CITY OF ELLENSBURG

Memorandum

Date: August 6, 2025
To: Zach Torrance-Smith, Kittitas County Planning
From: Craig Jones, City Development Coordinator *CJ*
Through: Derek Mayo, City Engineer *DKM*
Re: Plat comments for Pfenning 39 lot Plat LP25-00004

The following are the City Public Works comments for the proposed 39 lot Plat in the 900 blk of north Pfenning Rd.

PHENNING ROAD PRELIMINARY PLAT
A PART OF SECTION 31
TOWNSHIP 18 NORTH, RANGE 19 EAST, W.M.
KITITITAS COUNTY, WASHINGTON

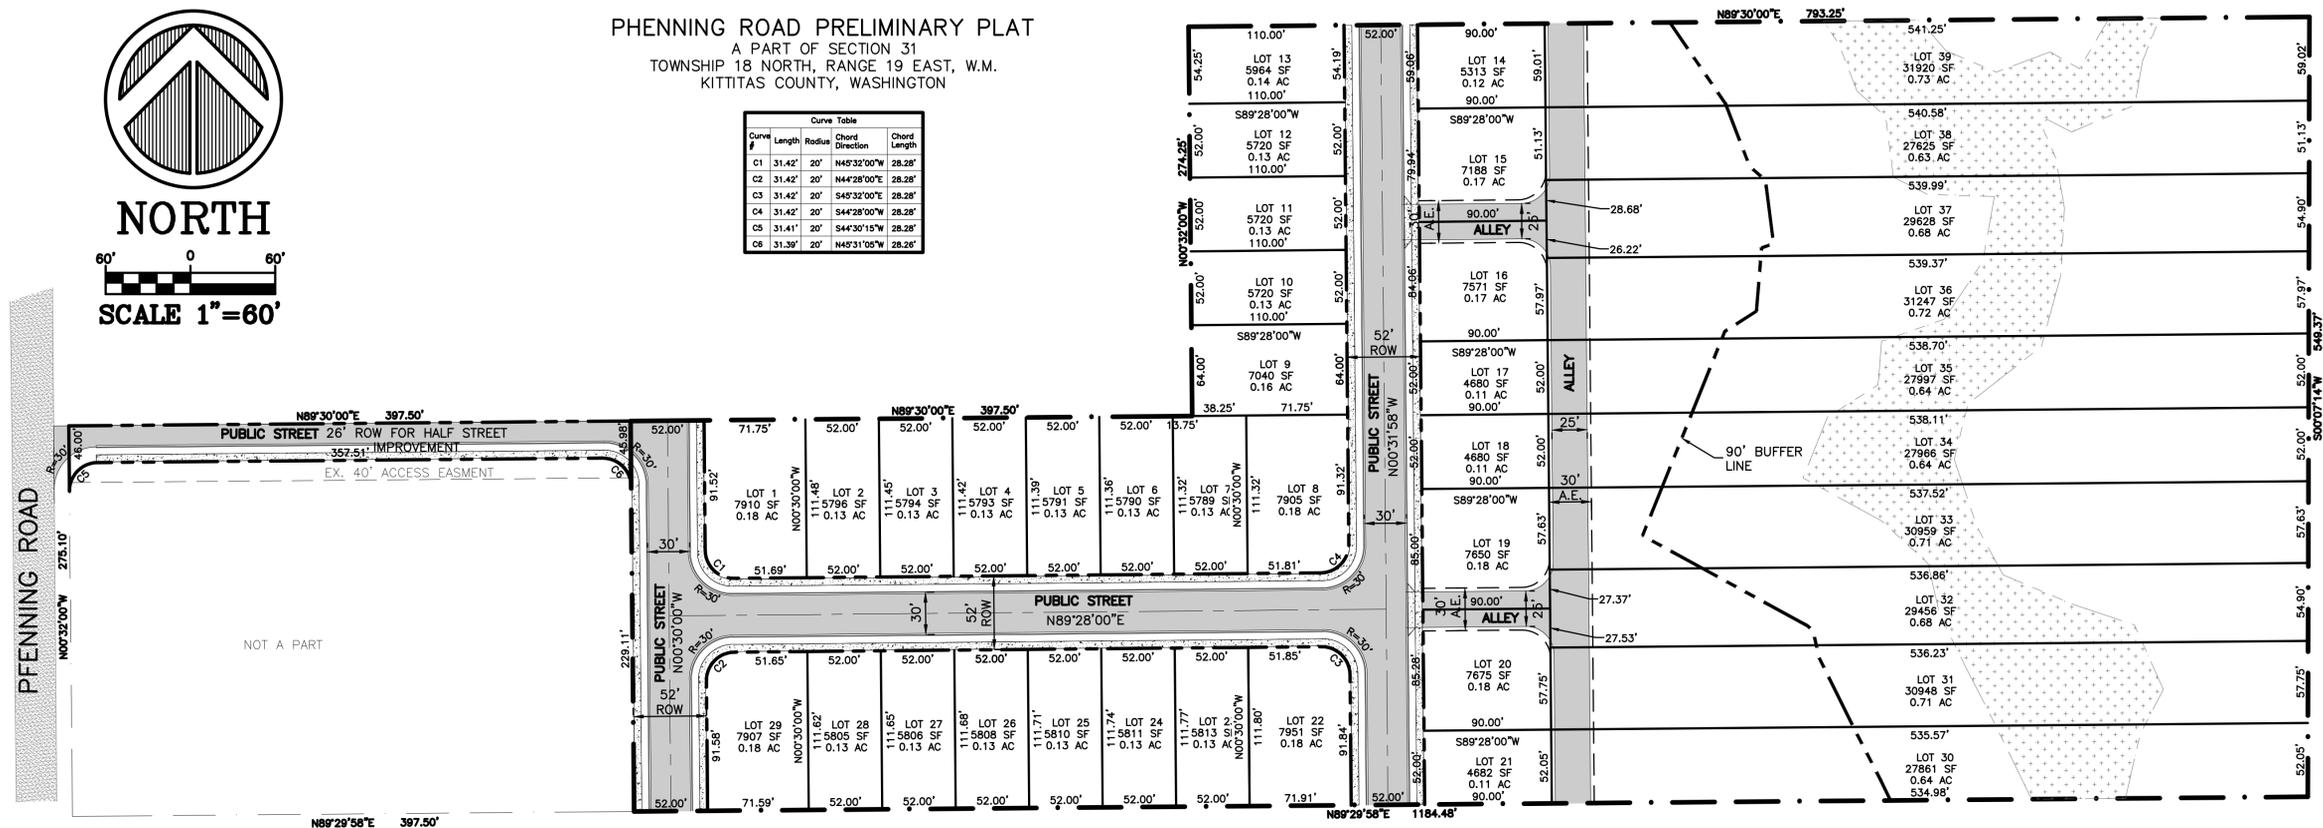
The water main available to serve this development is a 12" Ductile Iron main that runs in Pfenning Rd. There is an 8" existing stub in the proximity of the proposed access road. The developer will need to build an 8" water main on all the proposed interior roads. Each lot will need a separate water service. The maximum number of lots that can be served by one water connection is 40 lots. Larger water service lines may be required for any lot that will have a residential fire sprinkler system. Looping of an interior water main may be needed depending on fire flows. See attached utility map.

The sewer main available to serve this development is a 12" PVC main in Pfenning Rd. There is an 8" existing stub in the proximity of the proposed access road. The developer will need to install 8" sewer mains on the interior roads and side sewer stubs to each lot. See attached utility map.

This project will trigger the requirement for half street improvements along the access road with a new road entrance off Pfenning Rd. The access road will require dedication of public right of way or preserved through a perpetual public roadway and utility easement. The half road will need to be built to a minimum 20' wide standard. The engineer will need to verify turning movements and road widths are adequate for access. The interior roads will need full street improvements and have adequate turn-around that meet KVFR and City Development Standards. Street improvements include concrete curb/gutter, sidewalks, street lighting, permanent signage, asphalt, asphalt markings, gravel base, storm drainage, and other items associated with minimum public improvements consistent with Public Works Development Standards. Under the Land Development Code the sidewalks will need to be separated from the curb. Existing power poles may need to be relocated to accommodate these frontage improvements.

There is no storm system available for a direct discharge. The existing road side ditches will need to be conveyed across the frontages of the property. All storm facilities will need to be designed so they will not be inundated with ground water. Your engineer will need to verify groundwater during peak irrigation season to confirm the project will not be effected by it.
